Application Ref:	2024/0329	 Ribble Valley Borough Council www.ribblevalley.gov.uk		
Date Inspected:	02/07/2024		Site Notice:	N/A
Officer:	EP			
DELEGATED ITEM FILE REPORT:		REFUSAL

Development Description:	Demolition of existing garage and rear conservatory and construction of two-storey extension to side and single storey garden room to rear.
Site Address/Location:	15 Sabden Brook Court, Sabden BB7 9FY.

S. J. Bialecki
Drawing no 5007
Scale 1:50
Proposed Two Storey Extension At 15 Sabden Brook Court Sabden

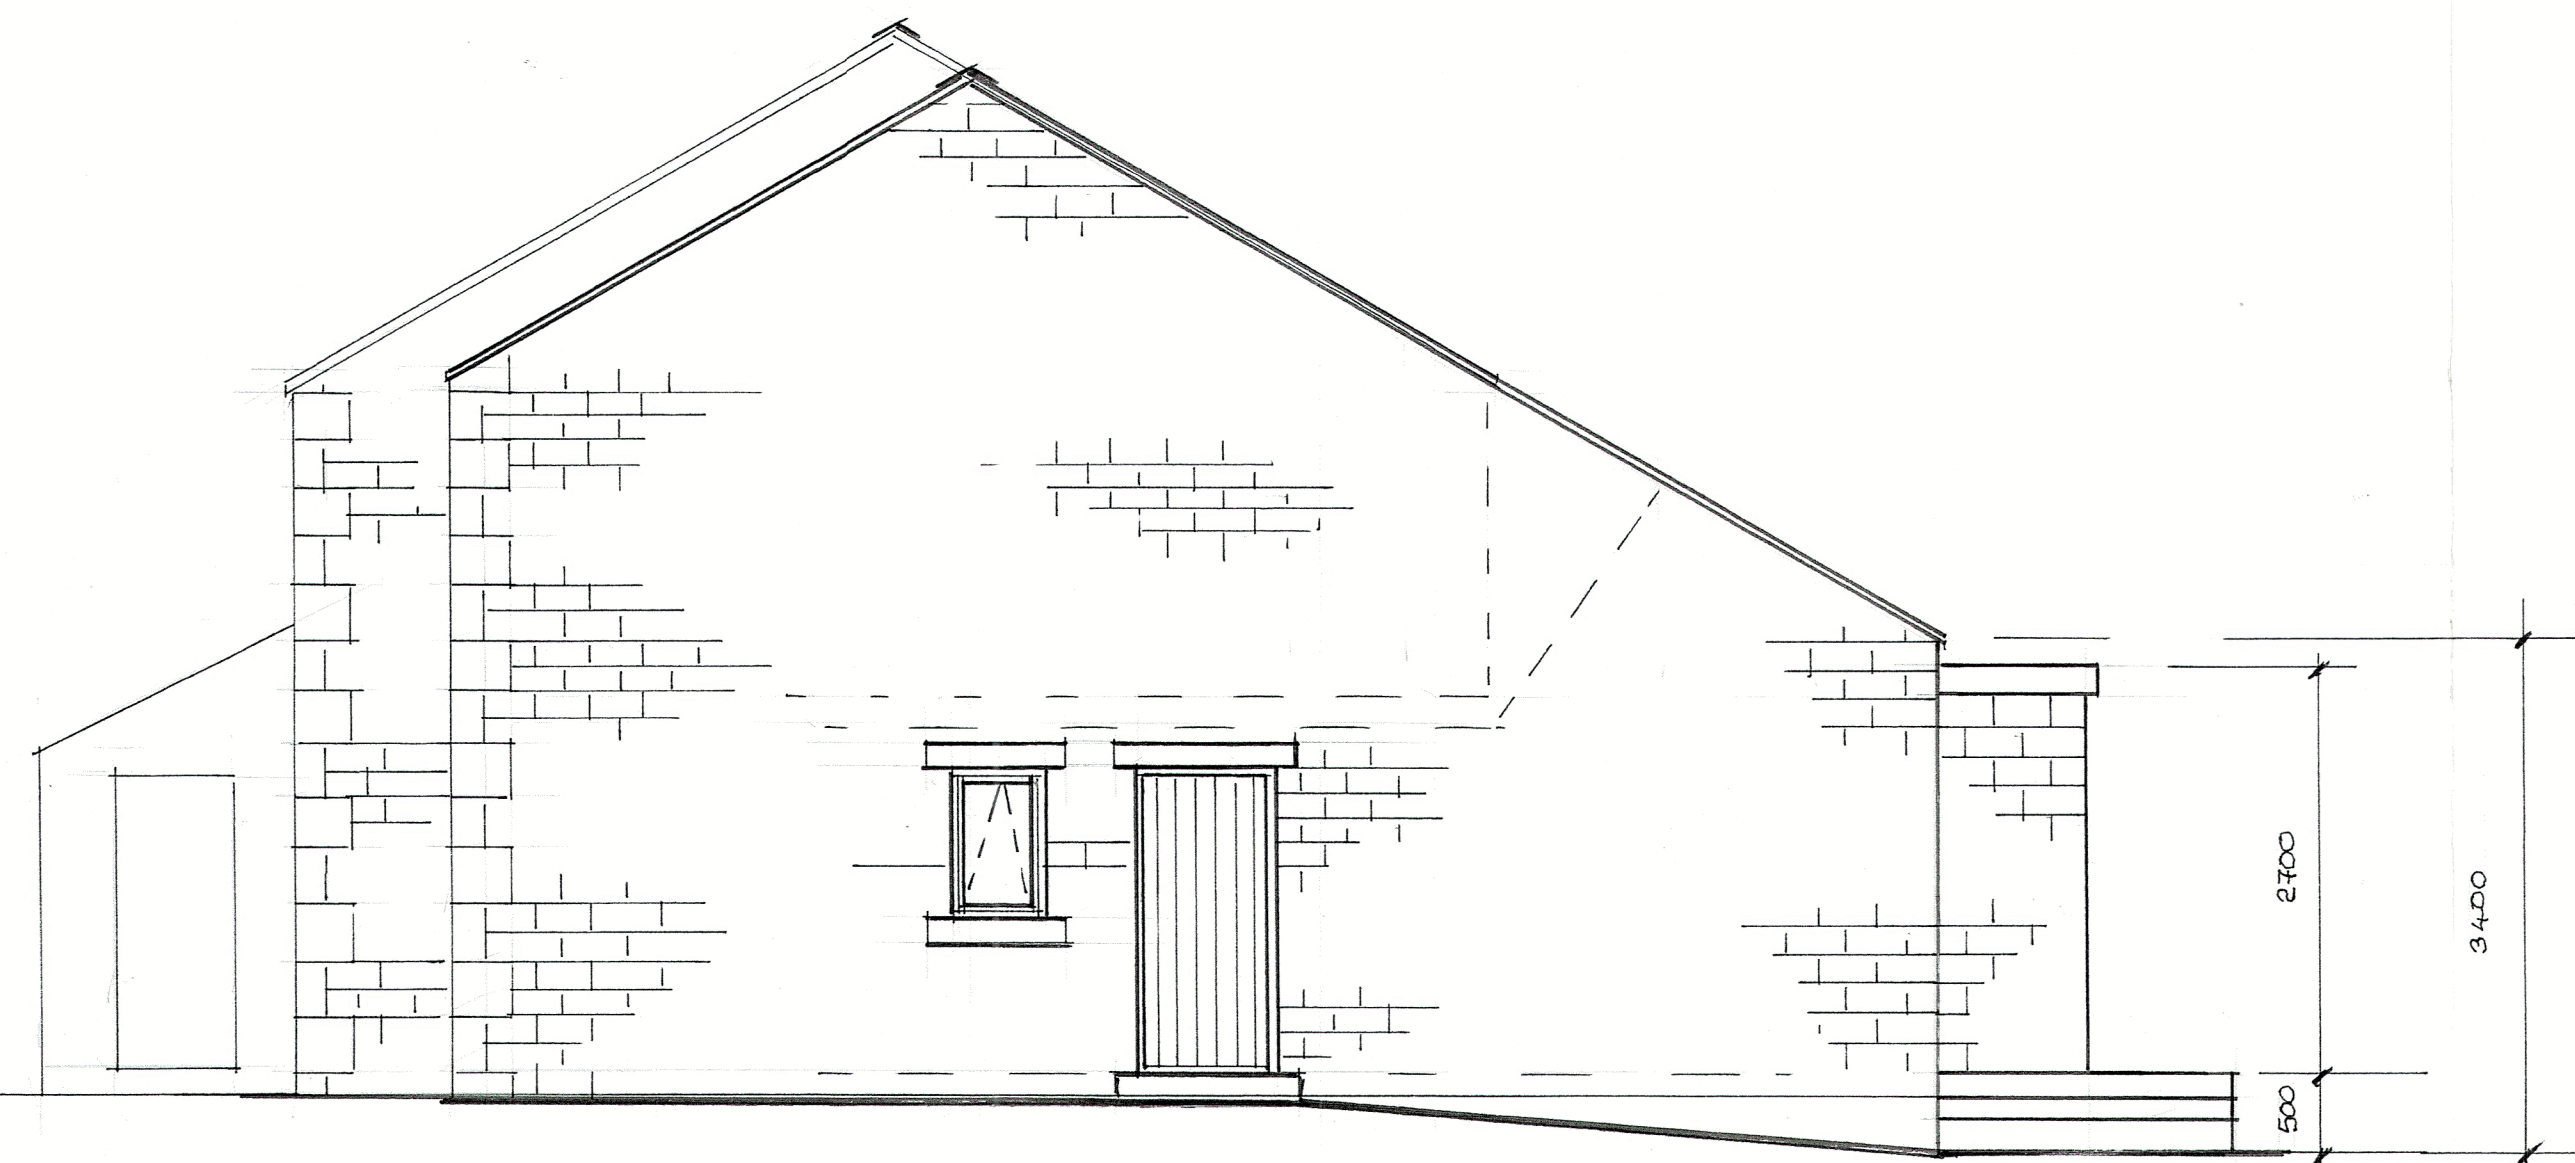
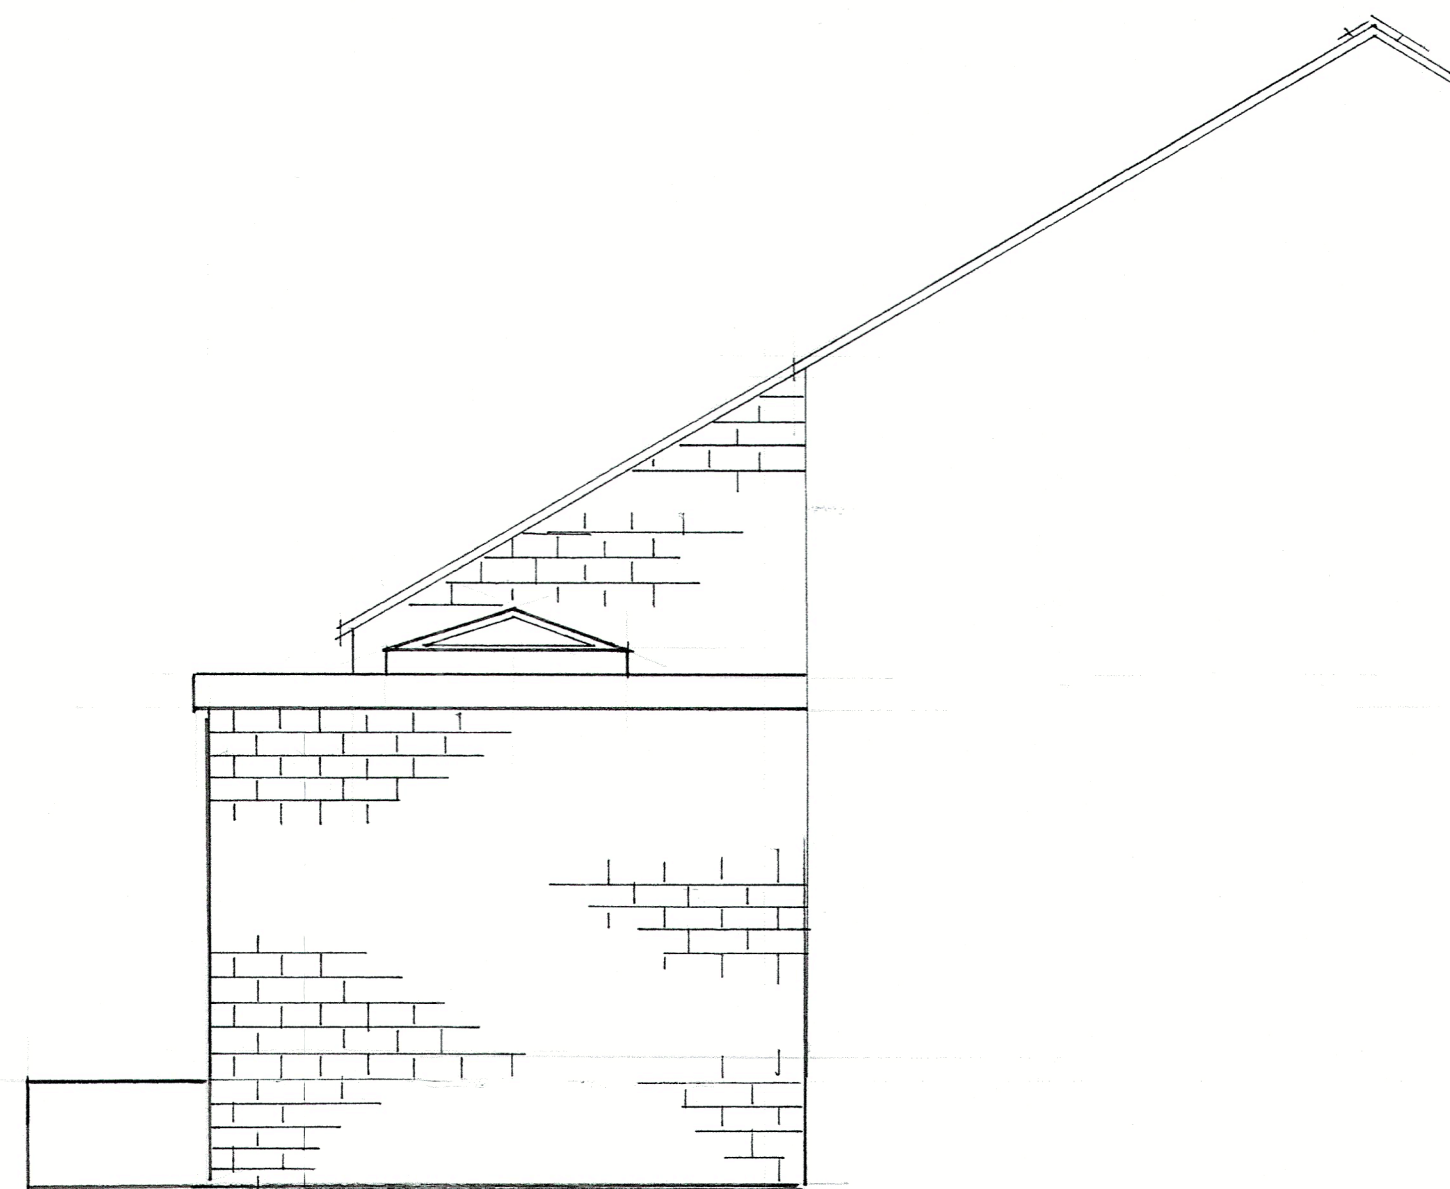
The proposed two storey extension will comprise an exaggerated roof slope, with the rear roof slope measuring approximately 7 metres from the ridge. This, paired with the 10-metre length of the proposed side extension, results in a disproportionate and dominating addition to the dwelling. The substantial scale and anomalous roof slope would read as incongruous within the street-scene given the levels of visibility afforded, particularly from the front and side, of the application dwelling. Furthermore, the surrounding area is comprised of traditional, linear built dwellings with a level of uniformity within the roofscape. This would be disrupted should the two-storey side extension as proposed be constructed.

As such, by virtue of the proposed two-storey side extensions scale, design and exaggerated roof slope, the introduction of the development would result in a dominant and anomalous addition to the application dwelling that would fail to respond positively to the existing linear formation within the street scene.

site plan

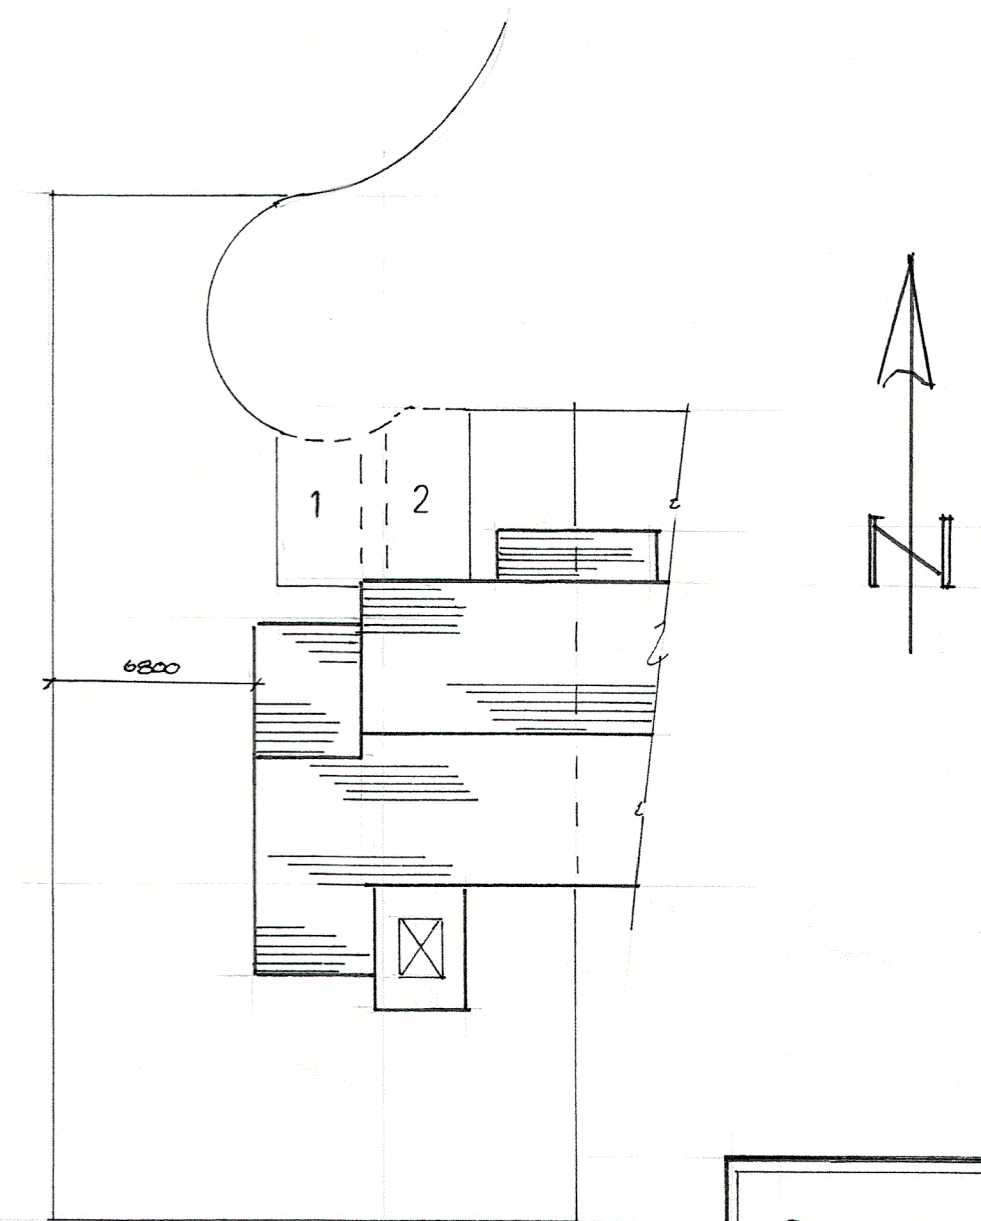
The proposed development would result in the loss of the existing garage, as well as the loss of approximately half of the existing driveway. This would leave the dwelling with only one off-road parking space. The dwelling is located within the turning head of the cul-de-sac and therefore any overspill parking would likely result in an obstruction for turning vehicles. Consequently, the shortfall in available off-road parking for a three bedroomed dwelling, if the development was implemented, cannot be supported.
